Re: PA23-018 – Pilchuck Rentals CUP – Technical Review 1  
Job. No.: 21c-4287

To: Amy Hess  
City of Marysville – Community Development Department  
501 Delta Avenue  
Marysville, WA 98270

### **Technical Review 1**

SITE PLAN

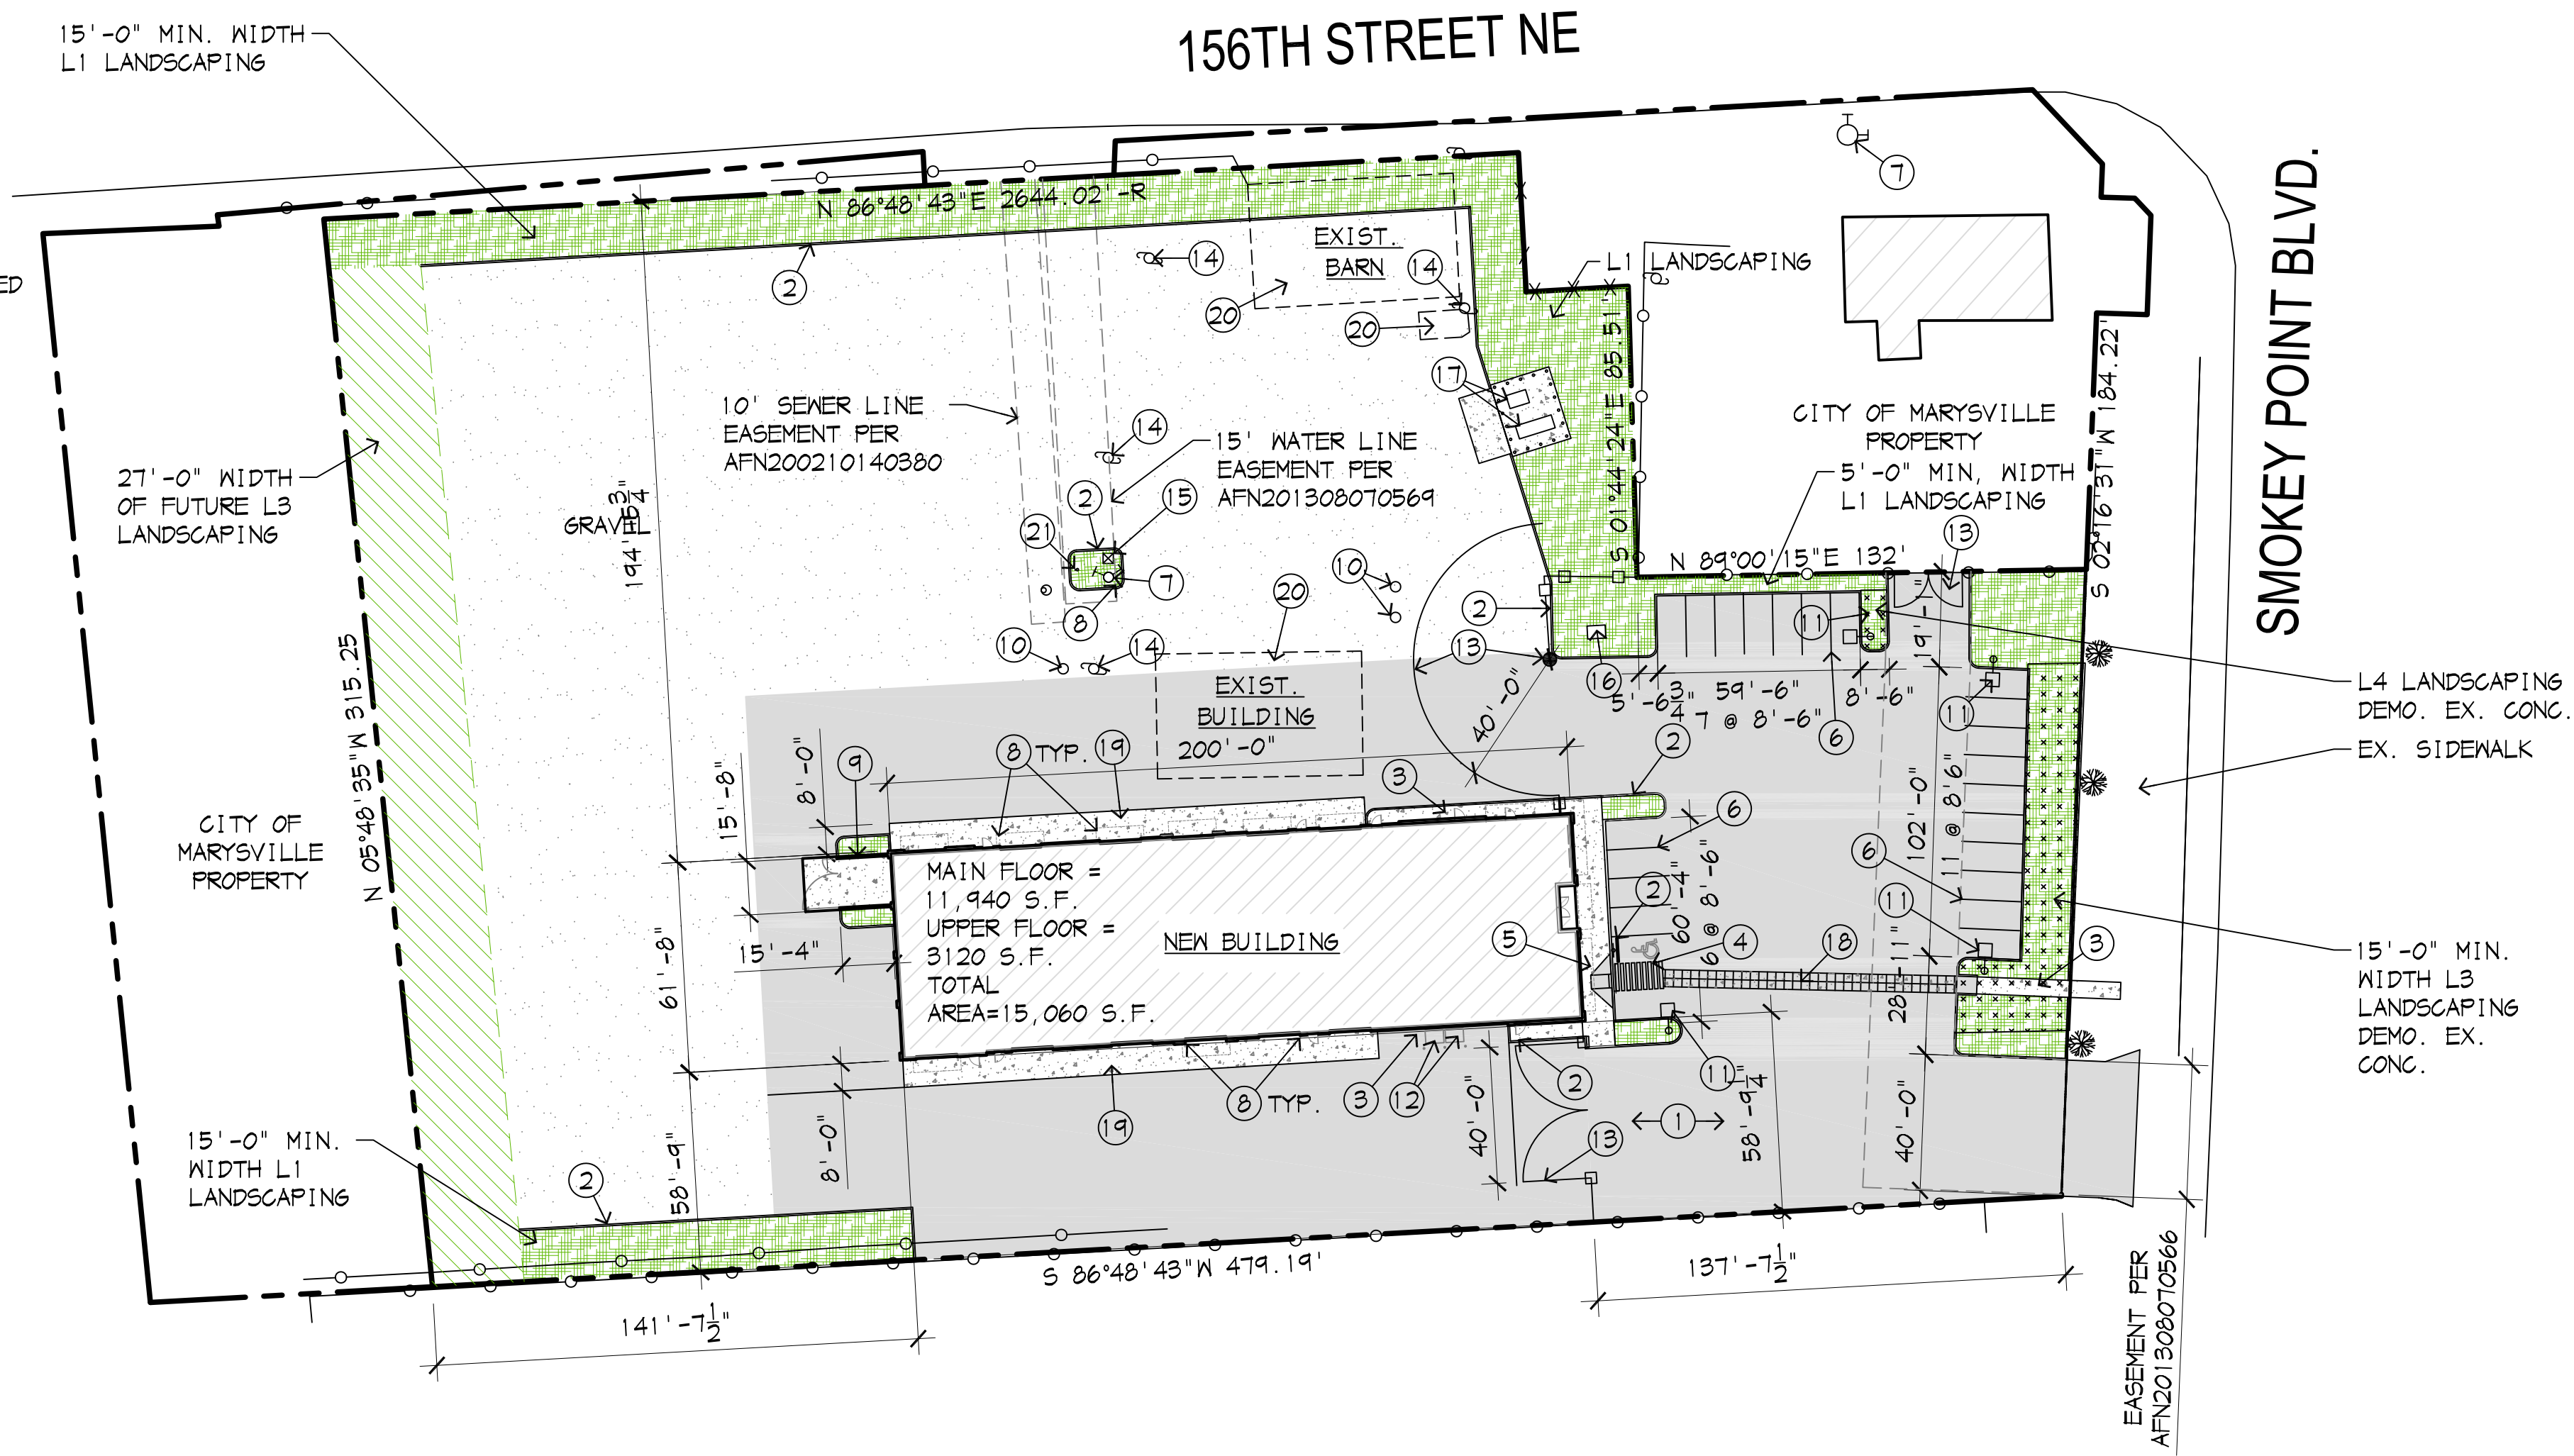
5. Impervious surface in the GC zone is limited to 85% of the total site. Please provide an impervious surface calculation with the revised site plan.

8. Utility meters, electrical conduit, and other service utility apparatus shall be located and/or designed to minimize their visibility to the public. If such elements are mounted in a location visible from the street or pedestrian pathway, they shall be screened with vegetation or by architectural features. This is expected to be a condition of CUP approval. It appears that the electric meter identified on the site plan by number 16 will need to be relocated as well as the propane tanks identified by number 17 on the site plan.

- a. The parcel has an easement to cross the City parcel to the north for access onto 156th Street. That access does not meet the spacing requirement from the intersection, combined with the future WSDOT project, that access should no longer be utilized for anything other than a right out traffic movement.

b. The current access onto Smokey Point Blvd. also does not meet the spacing requirement from the intersection. The access should be relocated to the south as far as possible and an engineering variance would need to be submitted to justify that a full access be allowed. If not, the access would be limited to a right in and right out traffic movement. Any additional guidance provided by the Traffic Engineer on this shall be followed.

4. Site plan is to show the distance from the proposed structure to the property lines, from all sides of the building.

*The impervious surface has been calculated and is shown on A1.1. The site is under 85% impervious surface.*

*Refer to the Site Plan on A1.1 for relocated electric transformer (16) (revised from electric meter) and propane tanks (17).*

*The access to Smokey Point Blvd has been relocated to the south. Refer to the site plan on A1.1.*

*Refer to revised site plan on A1.1.*

*Noted. Refer to the site plan on A1.1.*

10 TRASH ENCLOSURE SECTION
1" = 1'-0"

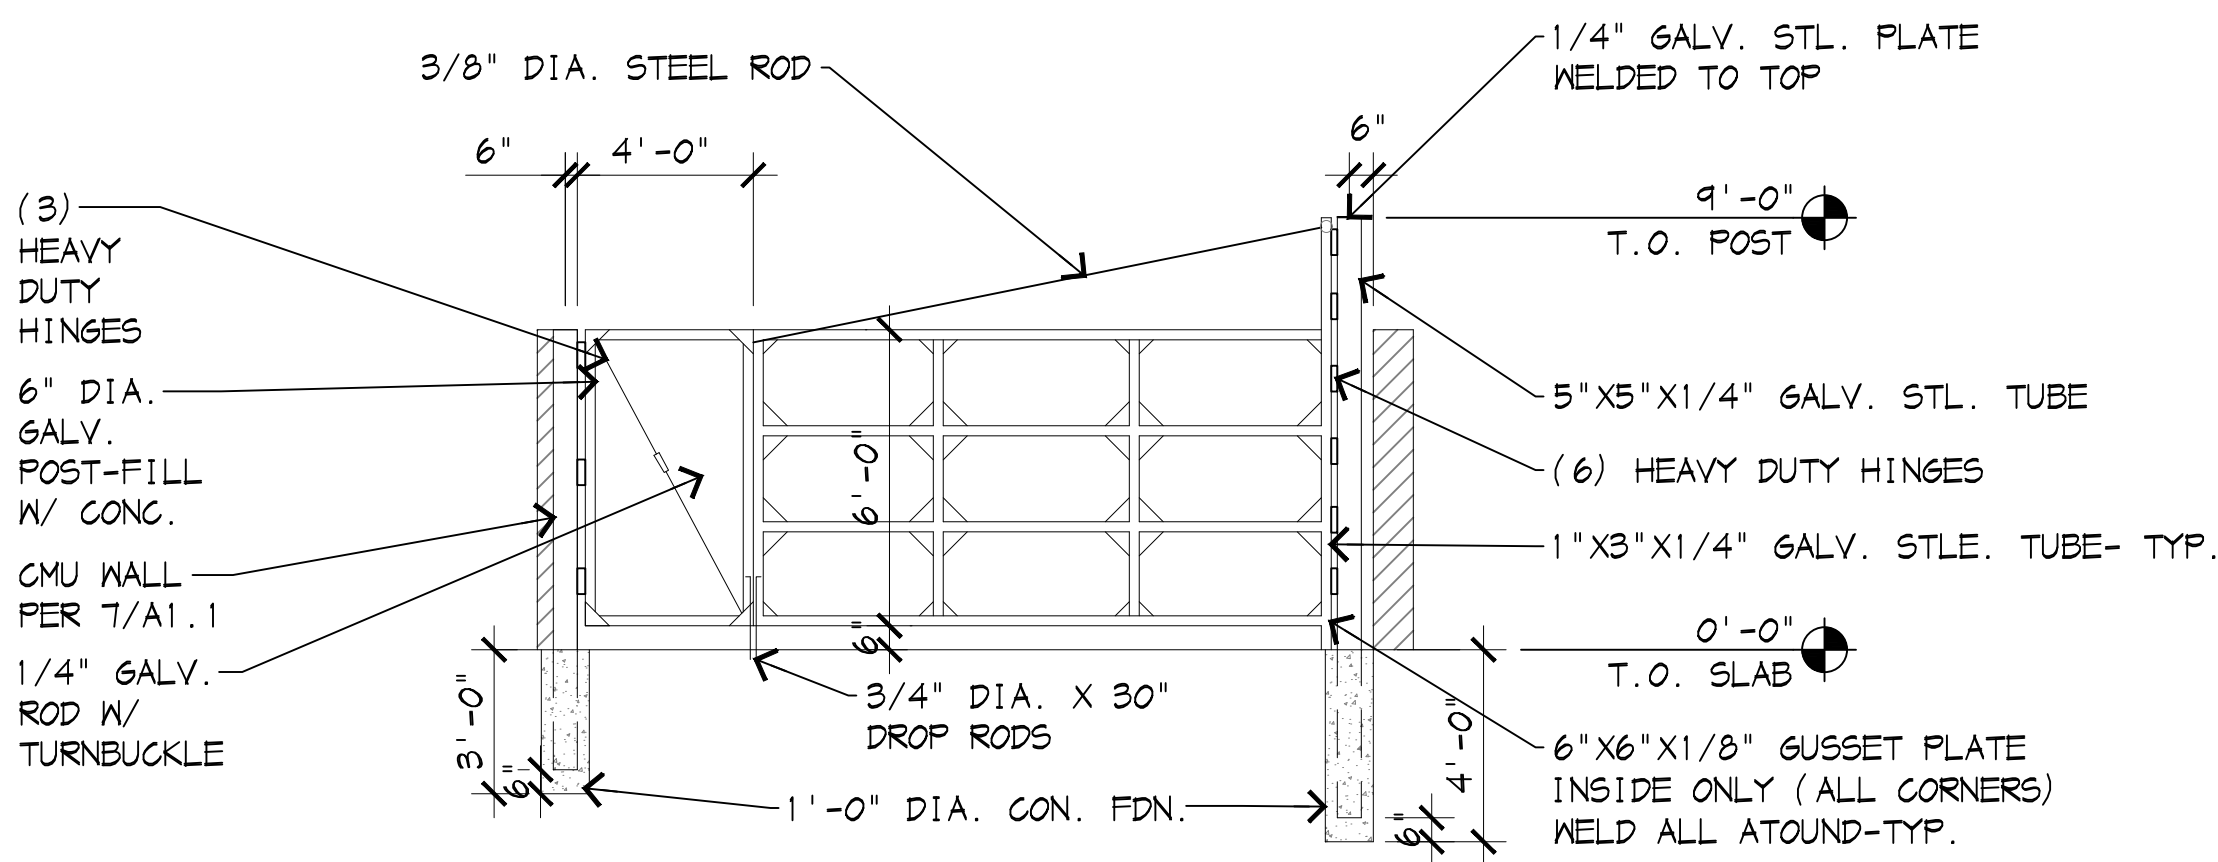
7. Please provide a dumpster enclosure detail. The site plan references sheet A1.2, but this sheet was not provided with the submittal. Please note that dumpsters are required to be located on concrete.

*Dumpster enclosure details are included in the re-submittal package.*

LANDSCAPE PLAN

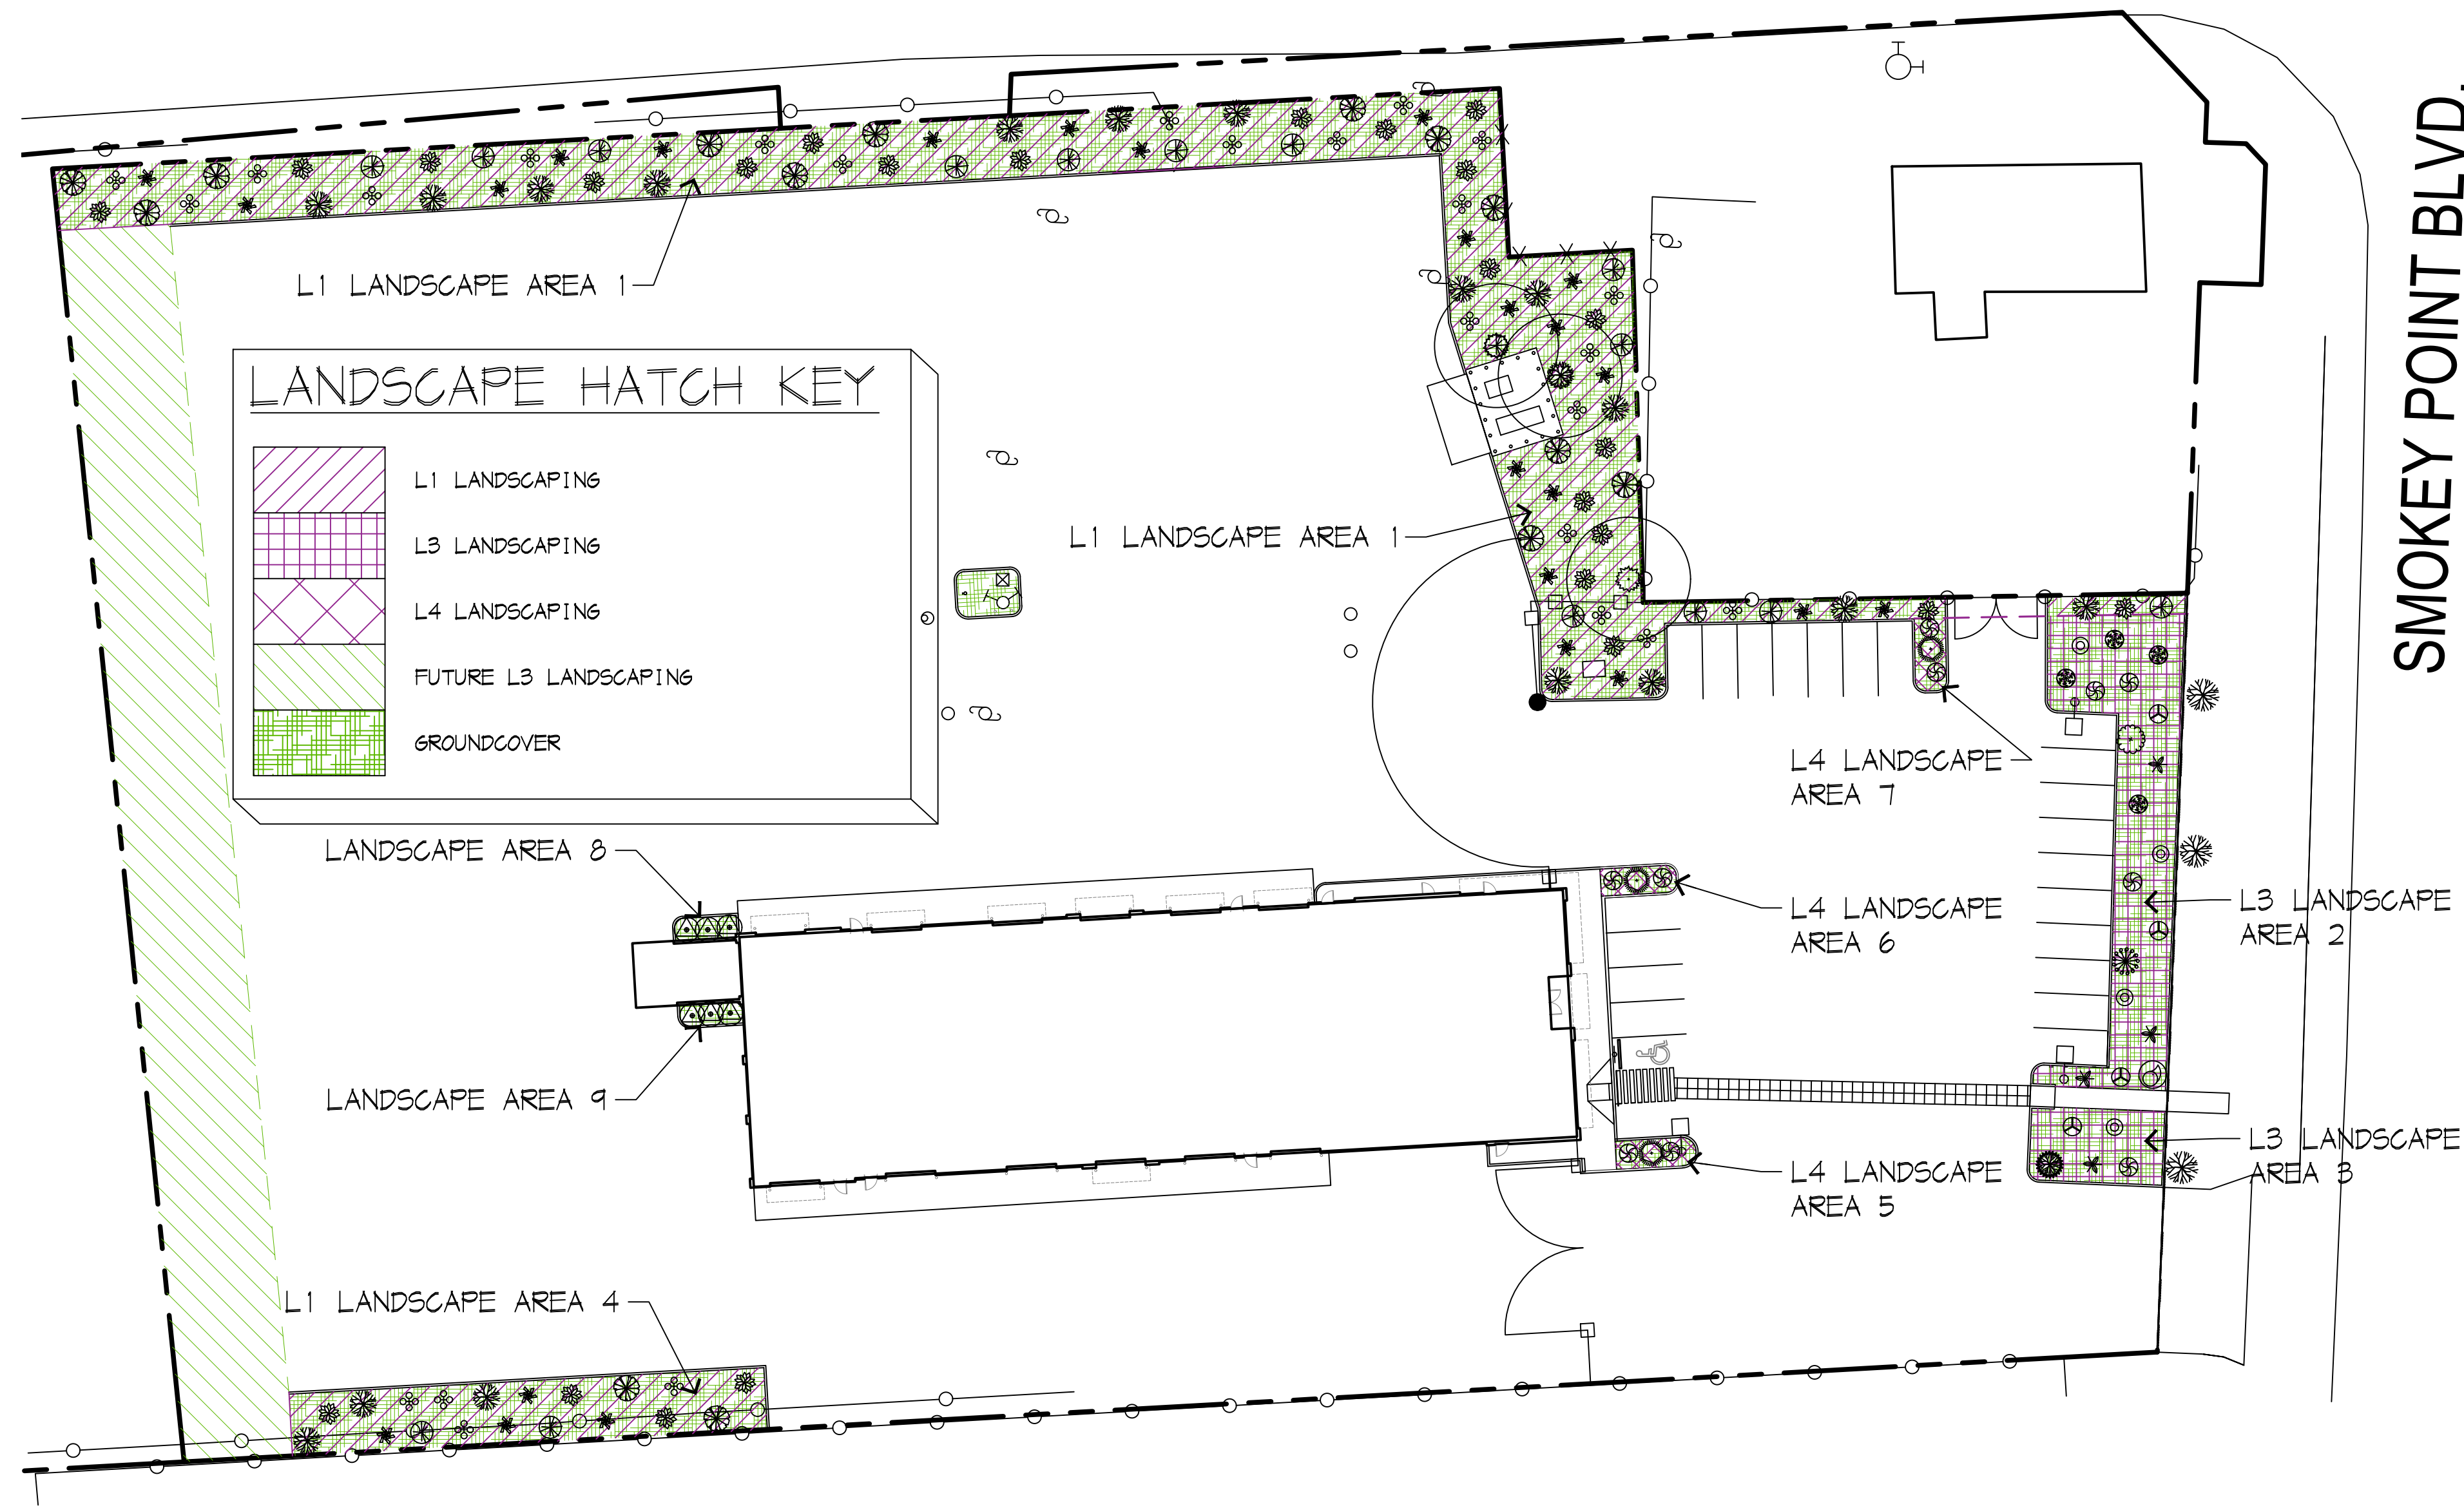
9. A landscape plan meeting the standards of [MMC 22C.120](#) shall be submitted. The plan shall include location, species, and quantities of all trees/shrubs/groundcover.

10. In order to screen the storage area, a 15-foot wide, Type L1 – Opaque screen shall be installed along the north, south, and west project boundaries. An L1 screen is defined as follows: A screen that is opaque from the ground to a height of at least six feet, with intermittent visual obstructions from the opaque portion to a height of at least 20 feet. An opaque screen is intended to exclude all visual contact between uses and to create a strong impression of spatial separation. The opaque screen may be composed of a wall, fence, landscaped earth berm, planted vegetation, or existing vegetation. Compliance of planted vegetative screens or natural vegetation will be judged on the basis on the average mature height and density of foliage of the subject species, or field observation of existing vegetation. The opaque portion of the screen must be opaque in all seasons of the year. At maturity, the portion of intermittent visual obstructions should not contain any completely unobstructed openings more than 10 feet wide. The portion of intermittent visual obstructions may contain deciduous plants. Suggested planting patterns that will achieve this standard are included in administrative guidelines prepared by the community development department.

Please revise the landscape plan to include the required screening.

*Refer to A1.3 for the landscape plan.*

*Refer to A1.3 for the revised landscape plan.*
